Appeal Decision

Appeal Ref: APP/T2350/W/24/3350099

Scott House, Green Moor Lane, Ribchester PR3 2YR

- The appeal is made under section 78 of the Town and Country Planning Act 1990 (as amended) against a refusal to grant planning permission.
 - The appeal is made by Laura Proos against the decision of Ribble Valley Borough Council.
 - The application Ref is 3/2023/0720.
 - The development proposed is described as 'stable block.'
-

Proposed Site Plan 1:500

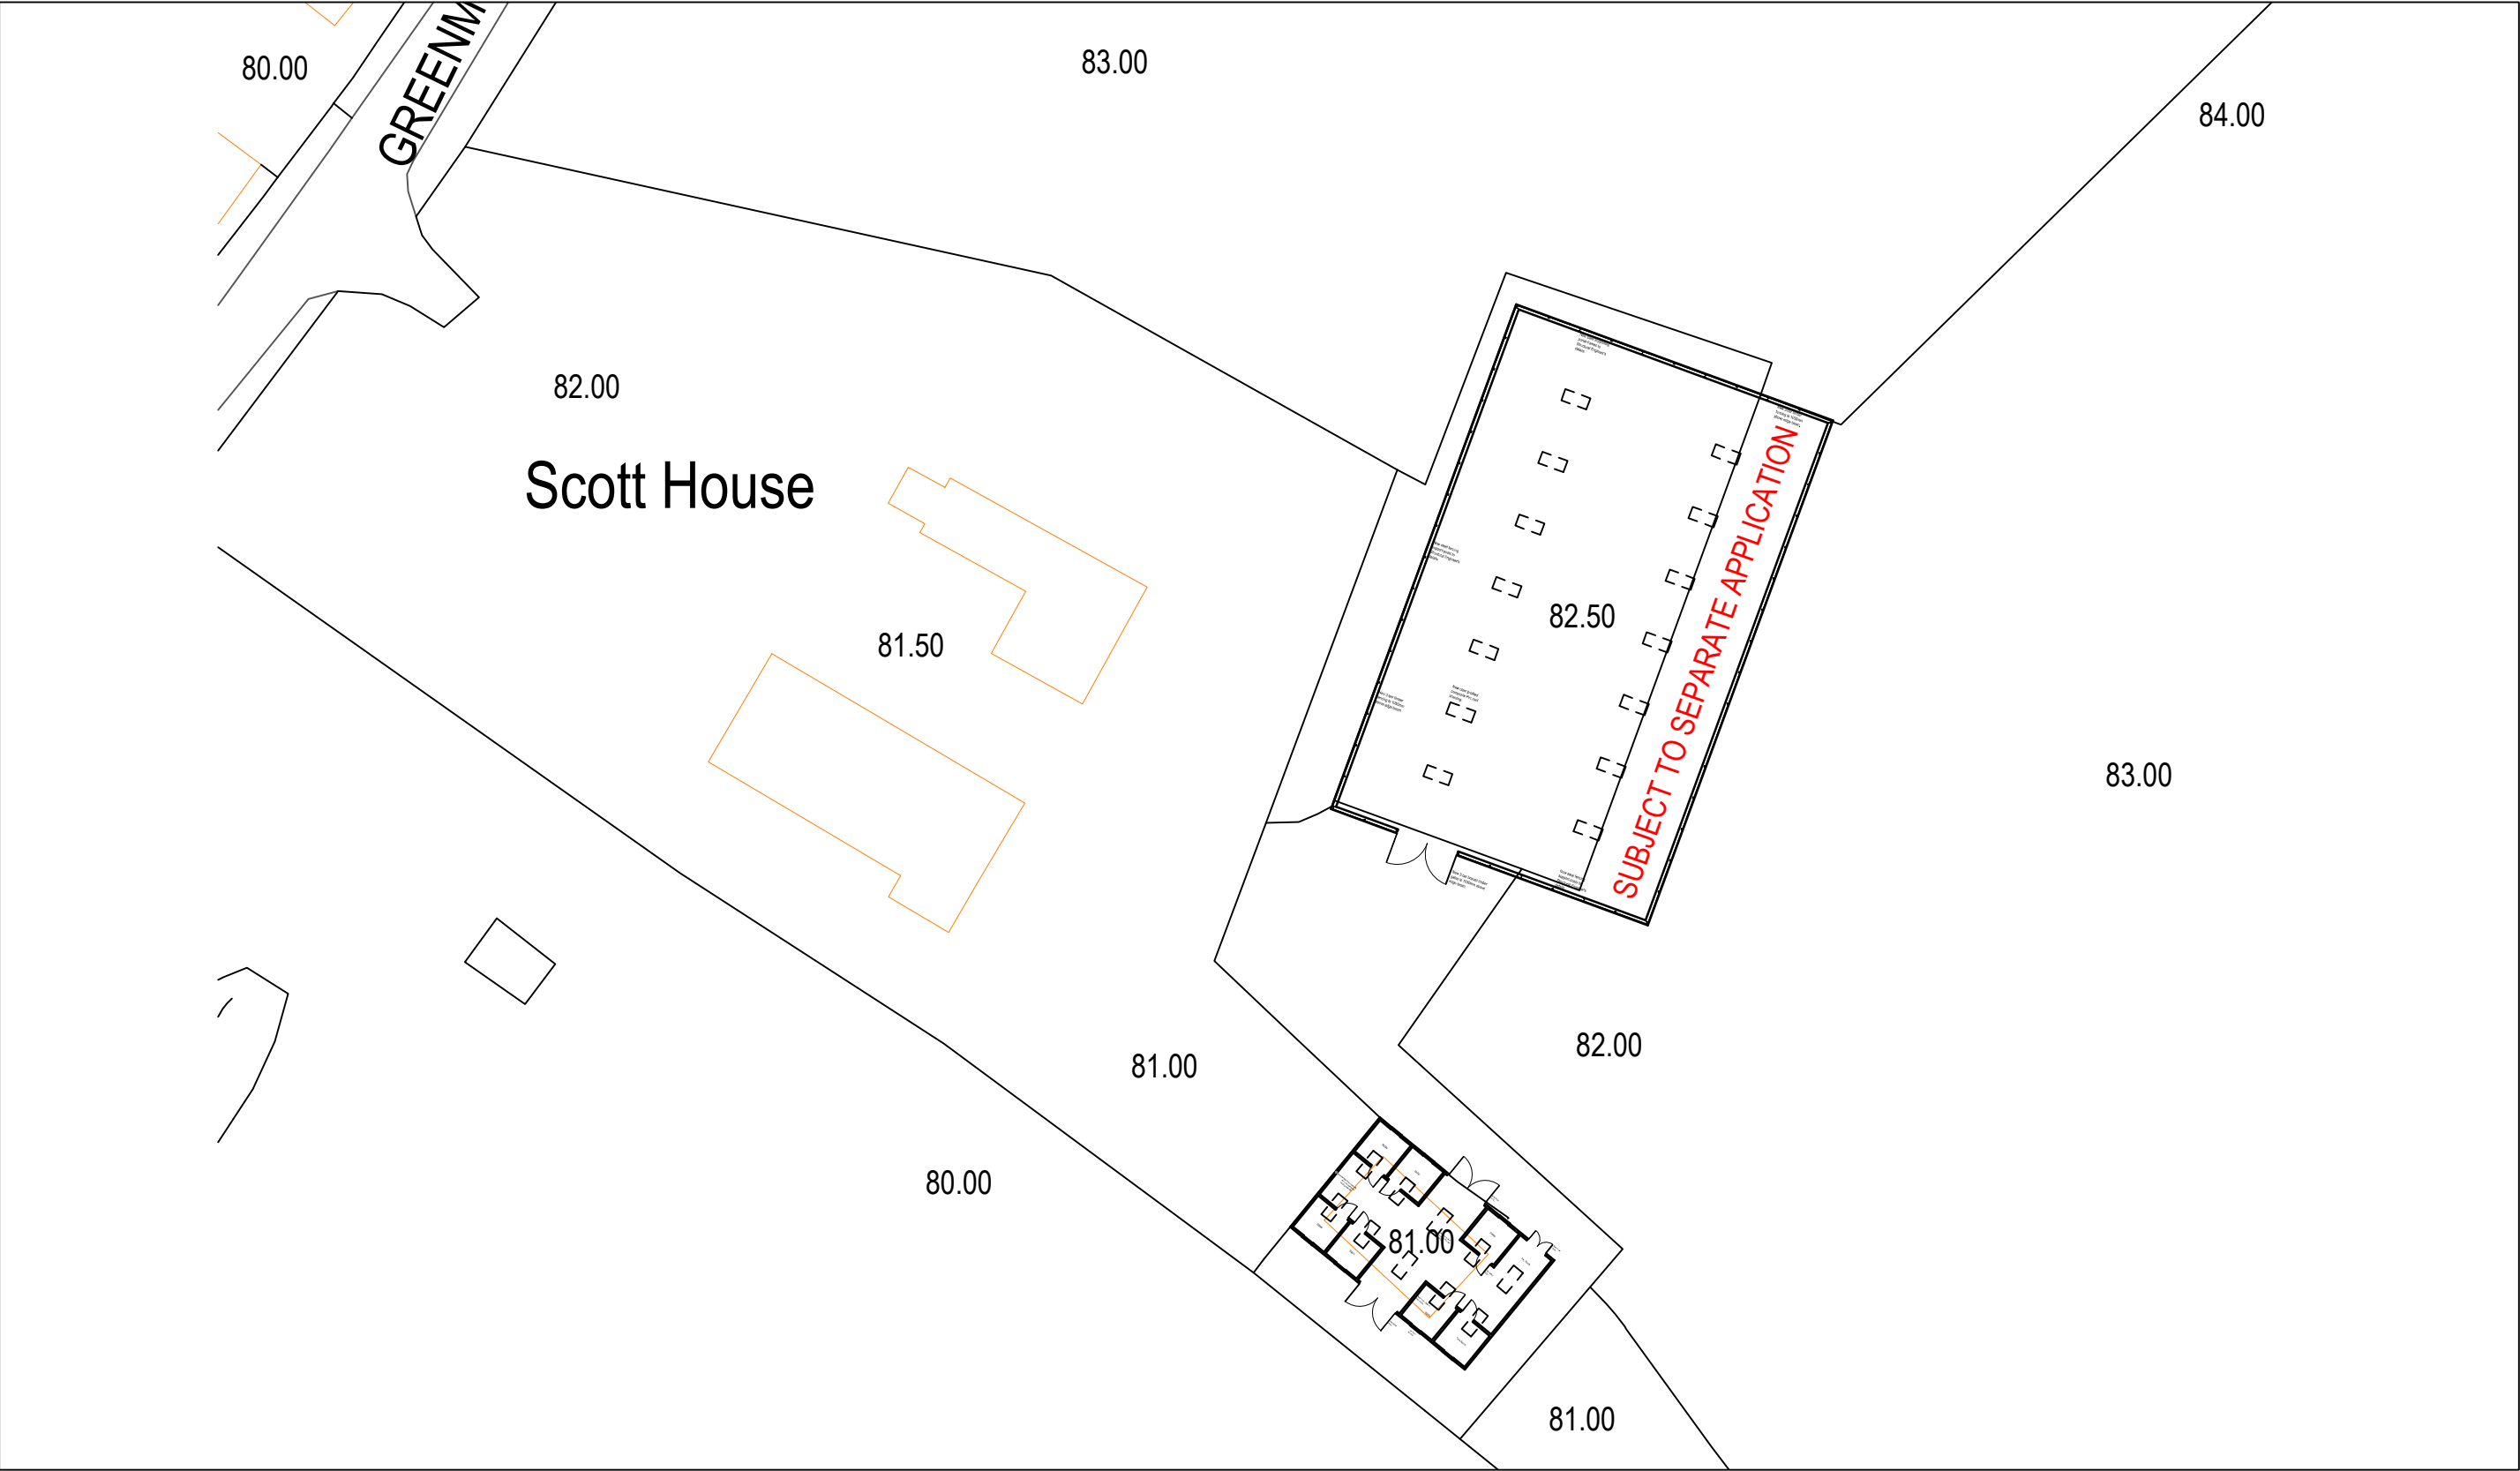
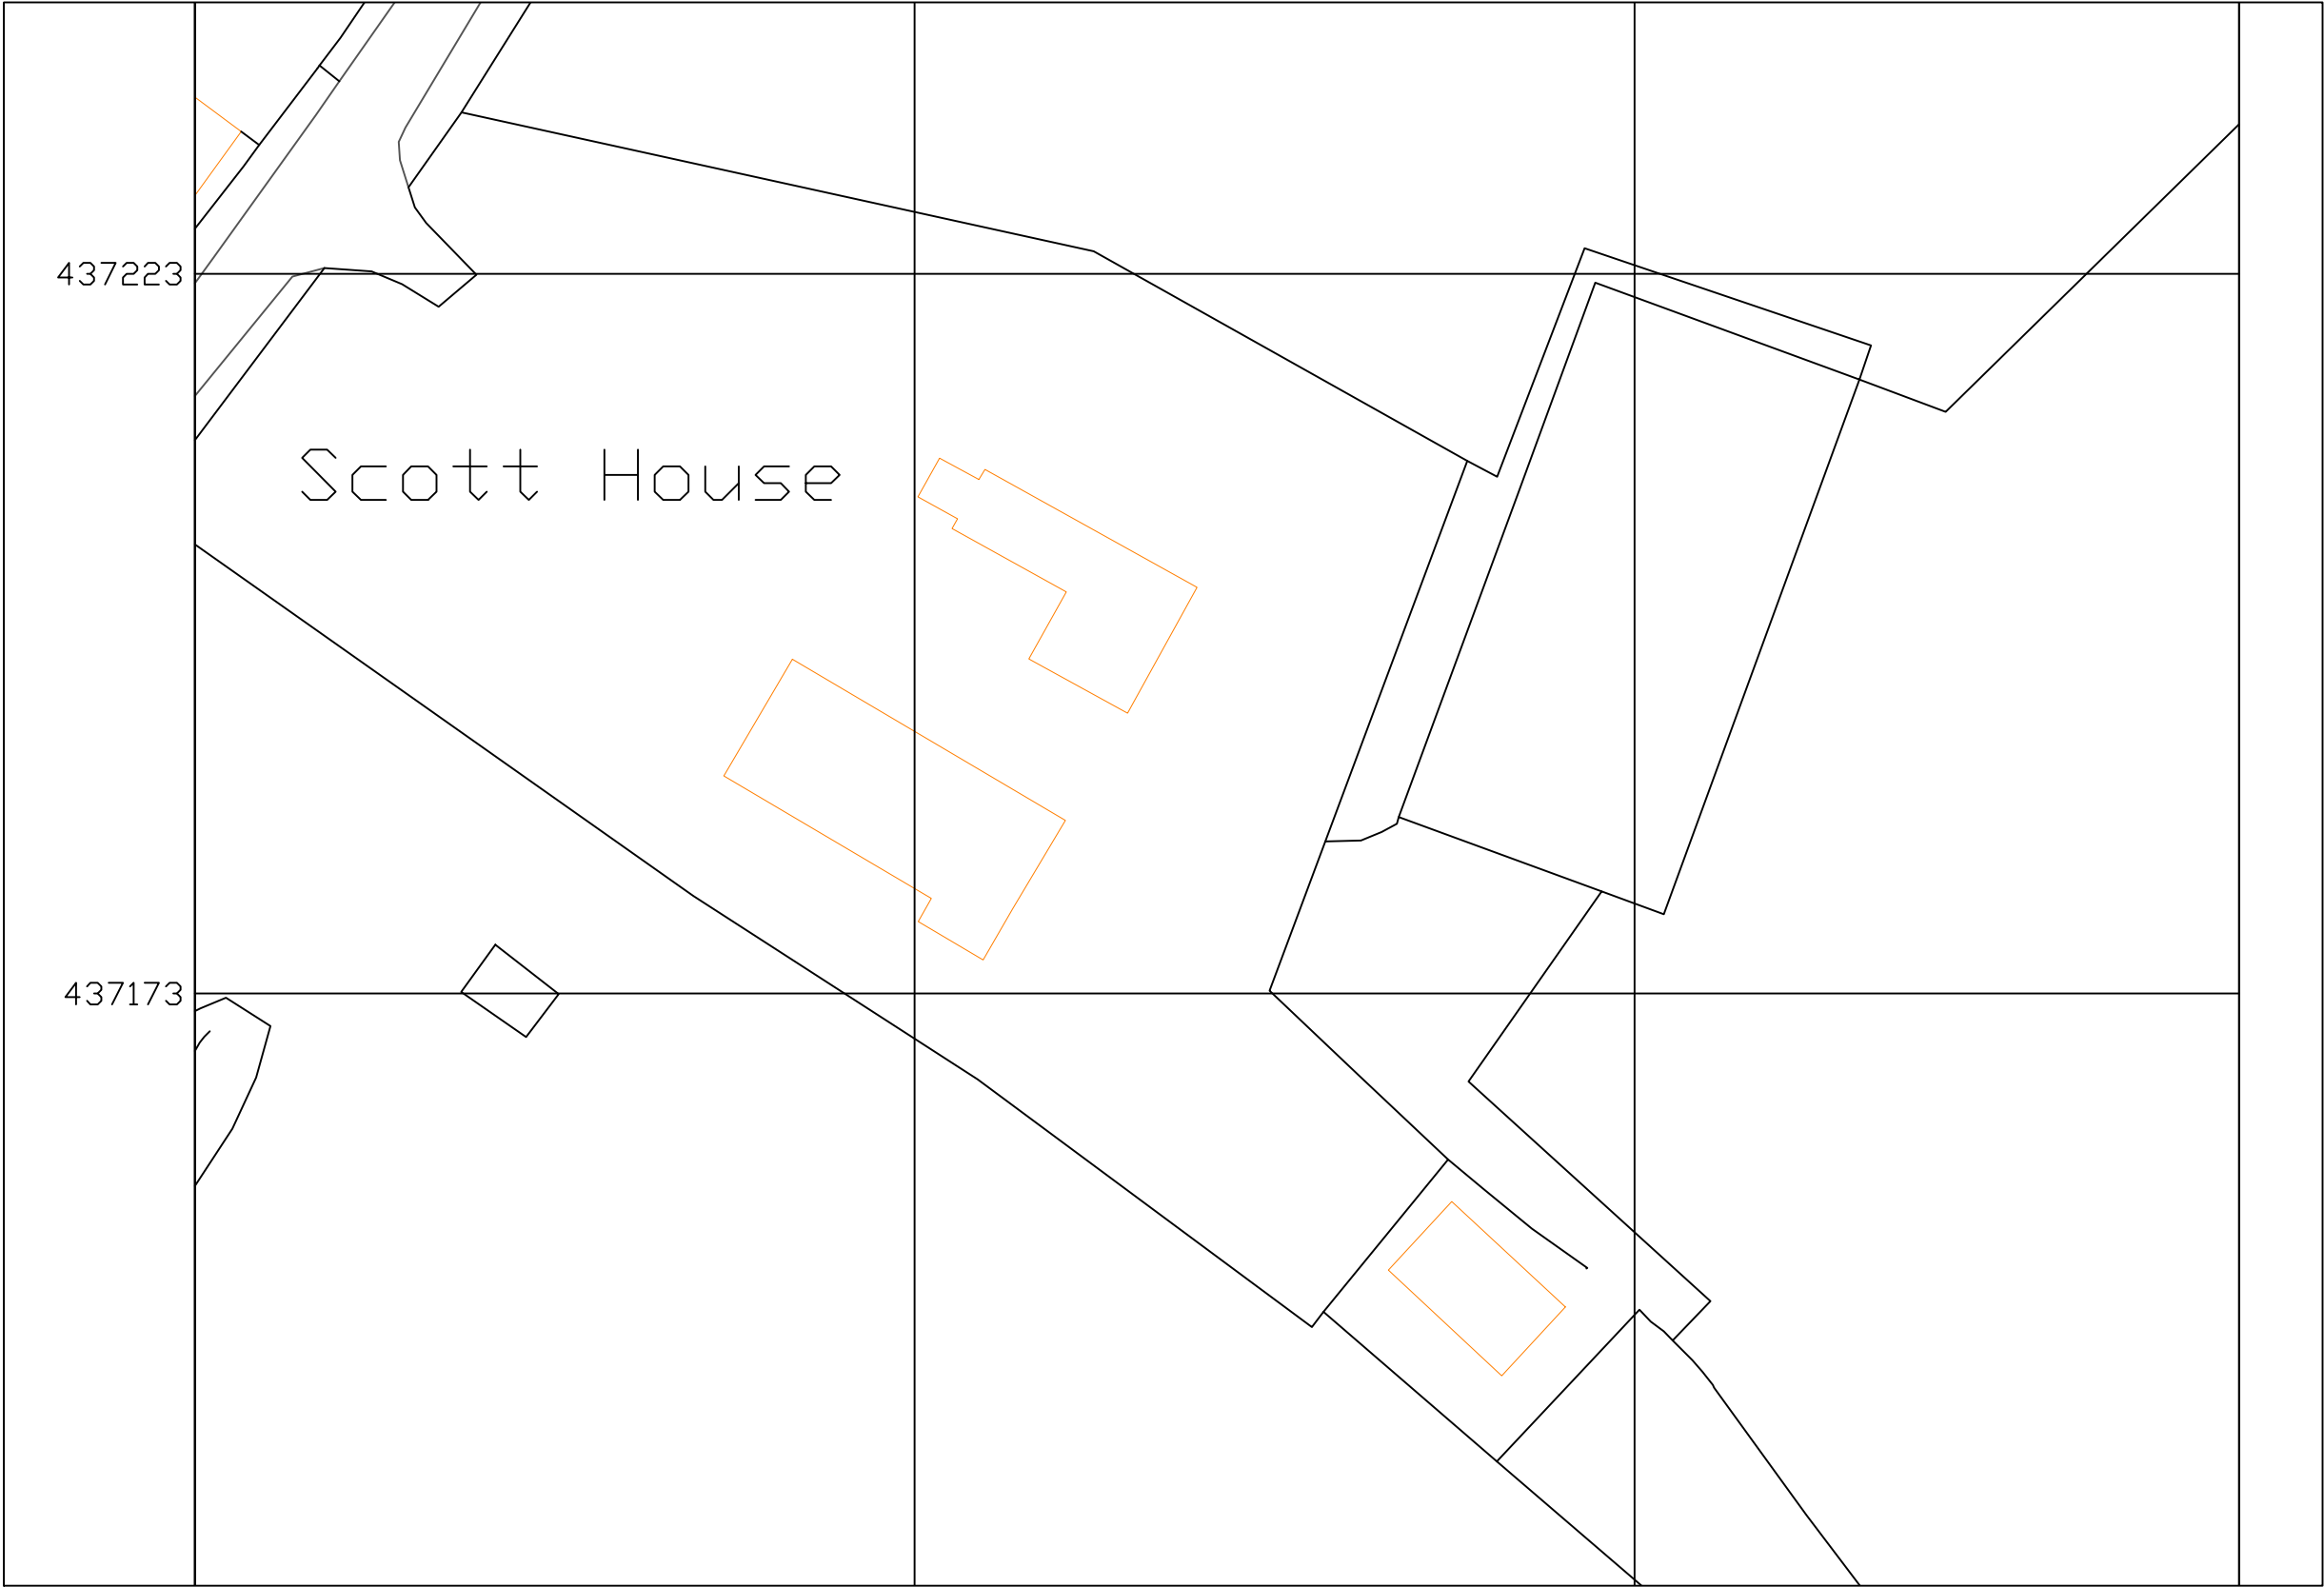
12. It appears from the plans submitted that the existing hedgerow to the north-east of the existing building would be removed to accommodate the larger footprint of the proposed building. This, along with the greater scale and form of the proposal would render it more conspicuous than the existing building in views from the PROW. If internal lighting was to be provided within the building, light spillage through the proliferation of windows would exacerbate the presence of the building, particularly in hours of darkness or inclement weather. I find that the increased scale and particular appearance of the building would be harmful in
